Subject: RE: P/125/14/PL and P/1/18/DOC land to rear of 251 Pagham Road, Pagham

Re: Planning Application No: P/125/14/PL - Land to the rear of 251 Pagham Road

Planning Application No: P/1/18/DOC

Requirement for work in the Reptile Translocation Area to the rear of 239 – 245 Pagham Road

drawing title	Landscape General Arrangement (East)				
drawing no.	1896-TF-00-00-DR-L-1002				P03
scale	1:250 @ A1	date	28.09.17	drawn by	AC
				checked by	AC

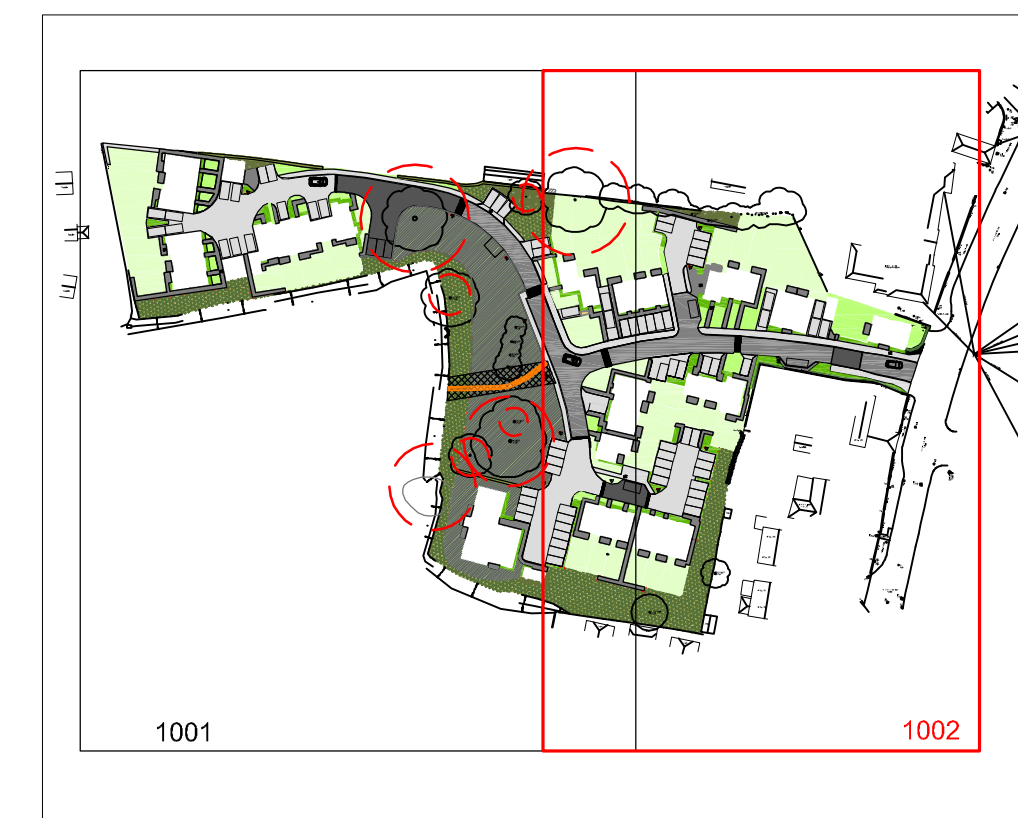
Also, on plans submitted with later application P/1/18/DOC, namely, 1896-TF-00-00-DR-L-3002 P04 and 1896-TF-00-00-DR-L- 1002 P05 they have designated this area EM4, and in the key on the drawing Area EM4 is designated as Wildflower grass seeding (ecological mitigation) Emorsgate EM4 - Meadow mix for clay soils.

I therefore, am writing to get this matter resolved as this area is now covered in weeds and stinging nettles which is obviously contrary to the planning permission. As the site is near to completion this matter needs to be resolved urgently.

In summary, the approved strategy for the site prior to demolition was to collect all of the reptiles and contain within a temporary holding pen. Then in the reptile receptor area we were to clear trees / clear scrub / sow the wildflower seed and allow to develop before we could release the reptiles from the holding pen into this area. This process was carried out.

I relayed the concerns expressed below to our consultant and whilst he is not overly concerned he has advised that the weeds will need to be kept on top of through occasional cutting to allow the grass / flowers to grow through. I have instructed our site staff to carry this out. (at least once a month down to 20 cm height).
